**Your Ref:** P/20/18/DOC

**Town & Country Planning Act 1990 (as amended)**  
**Town and Country Planning (Development Management Procedure) (England) Order 2015**  
**Approval of details reserved by conditions imposed under P/107/16/PL relating to conditions 3-**  
**surface water drainage, 4-schedule of materials & finishes, 5-landscape scheme, 6-screen**  
**wall/fence details, 8-site set up during construction, 10-storage of waste & recycling details , 11-**  
**placement of 2 No. nesting opportunities for birds & 14-external lighting details.**  
**7 Webb Close Pagham,,**

PROPOSED DRAINAGE PLAN

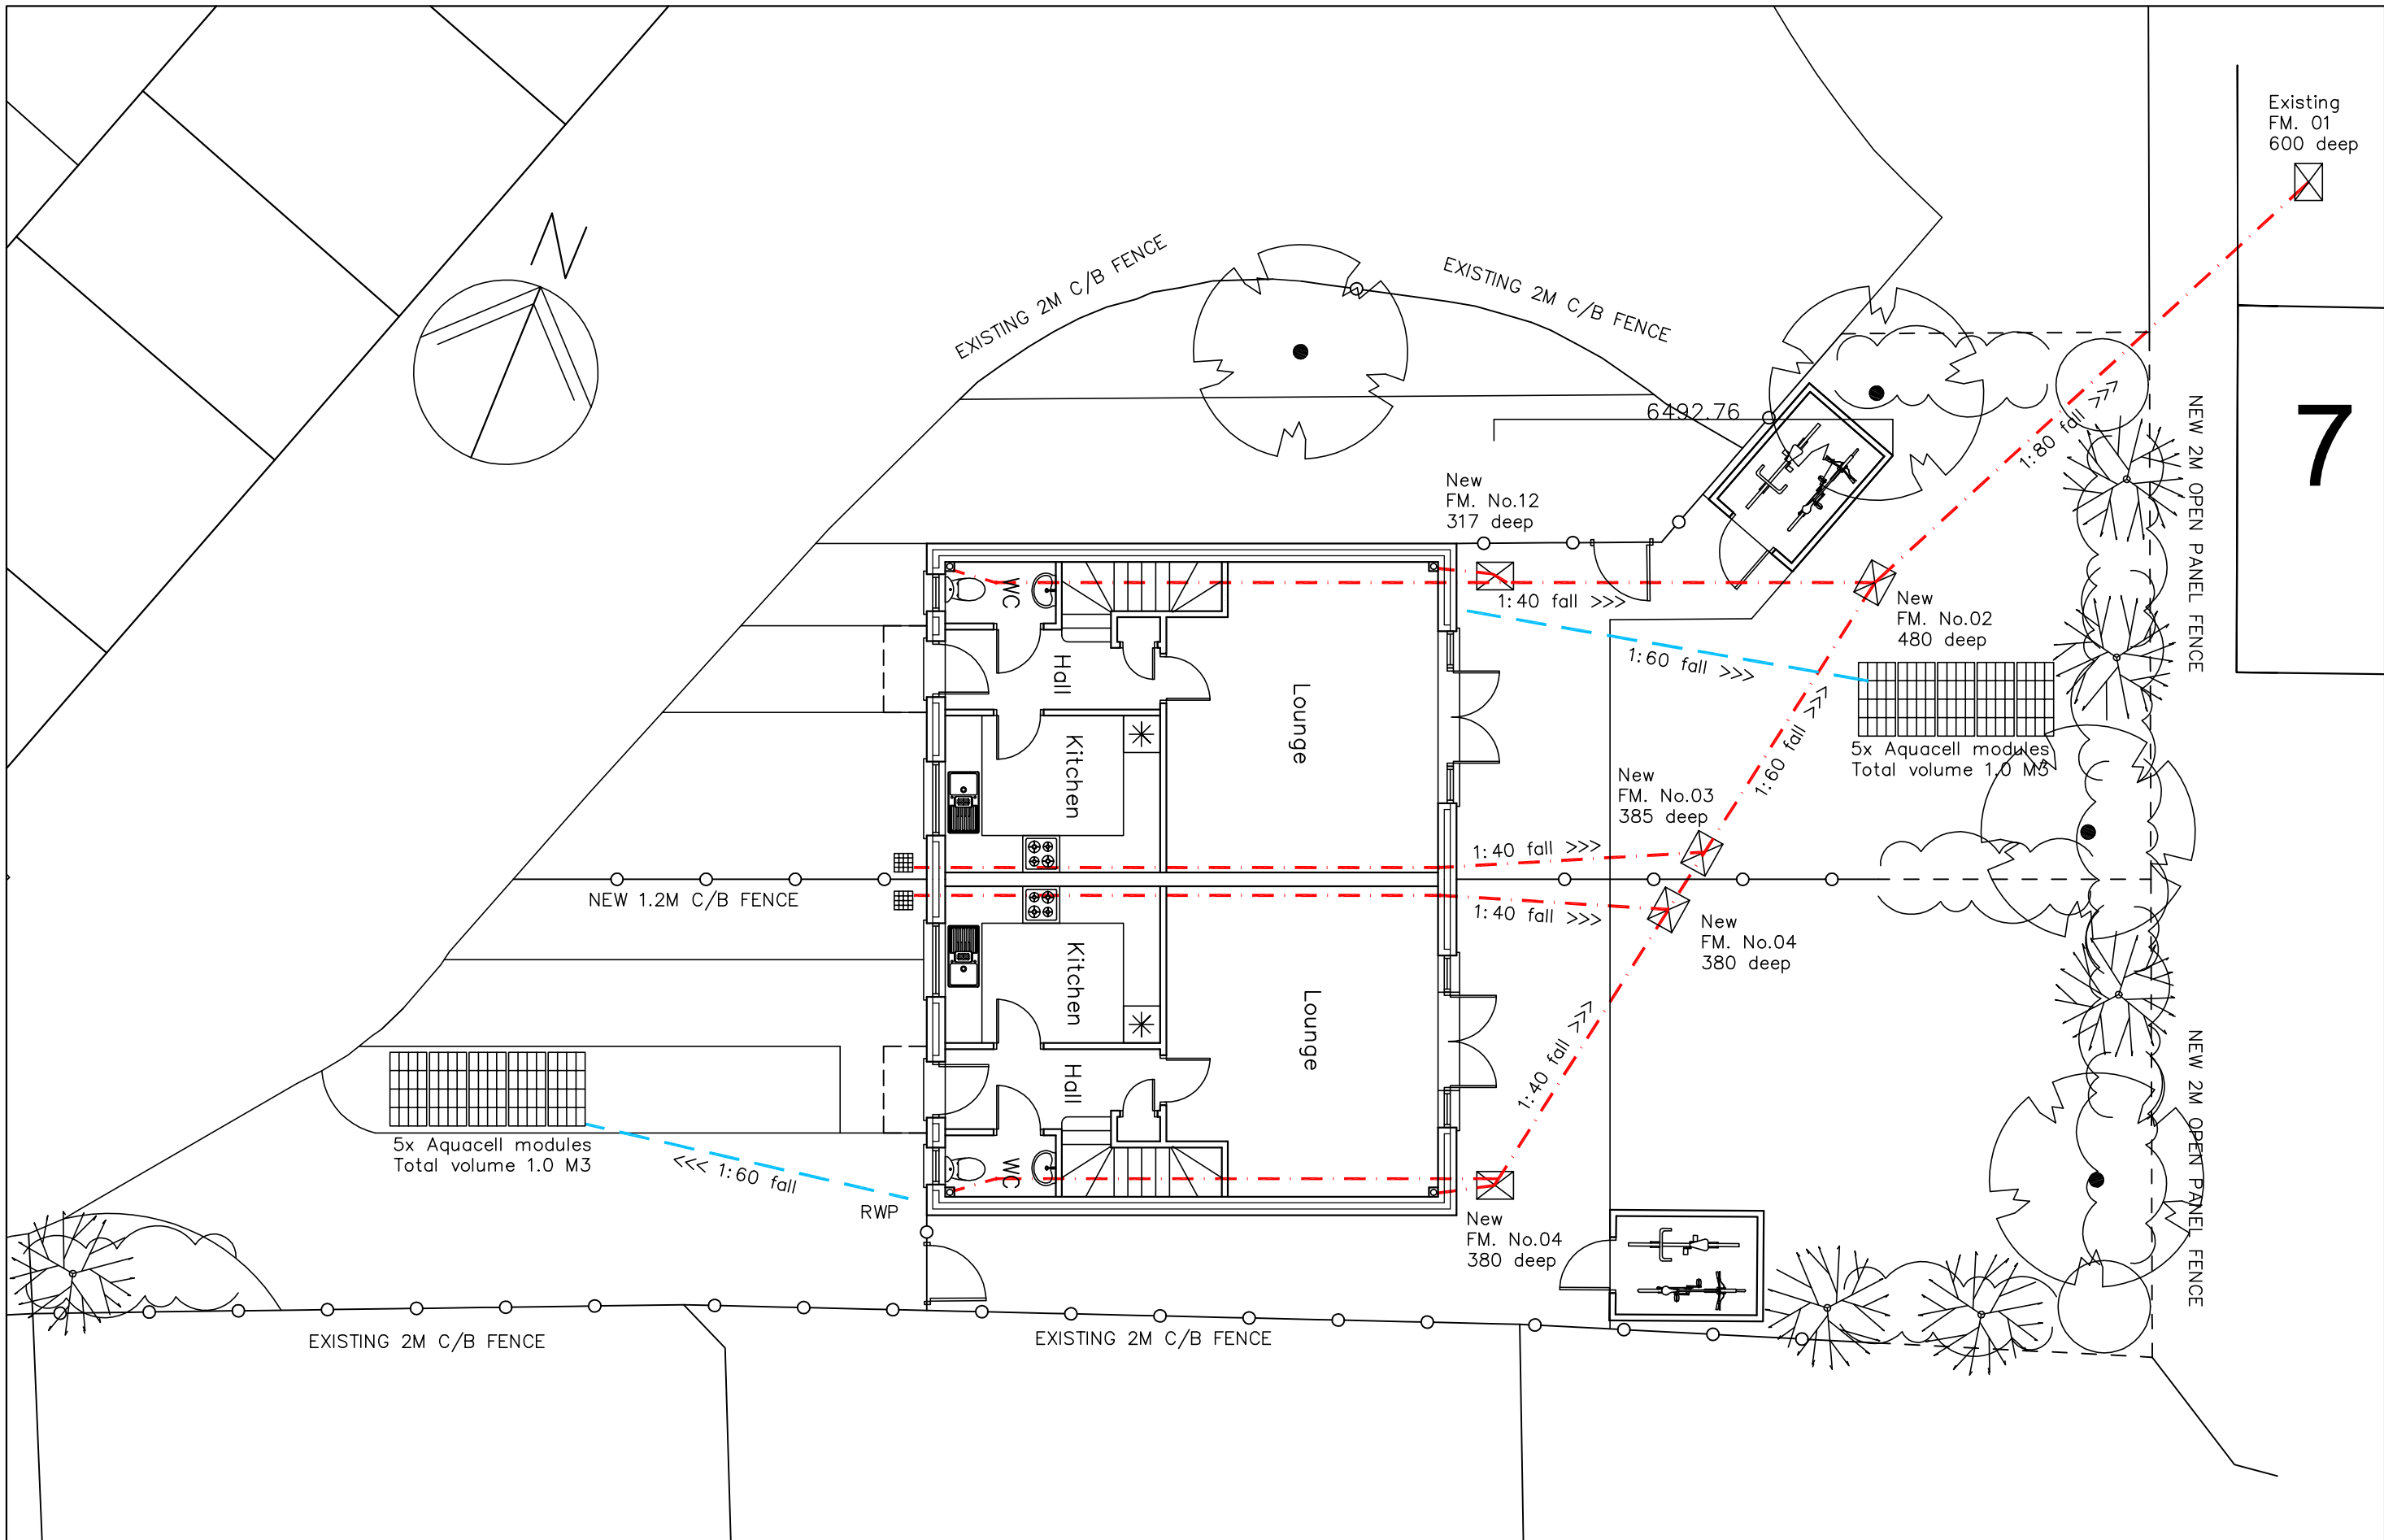
1. The applicant has not provided winter groundwater monitoring data or winter percolation testing data to BRE365, to support the design. This is critical;
2. The winter groundwater monitoring should coincide with high tides due to the possibility of tidal influence;

3. The drainage scheme will need to be fully detailed i.e. levels of incoming pipes/soakaway base levels, etc. Permeable pavements will need to include base/formation levels and finished levels;
4. Catchpits are required upstream of soakaways;
5. Full construction details for the soakaways, catchpits and permeable paving are required; and
6. Supporting hydraulic calculations for the soakaway and permeable paving designs, to prove that the 1 in 100 year storm event plus climate change can be accommodated within the systems.
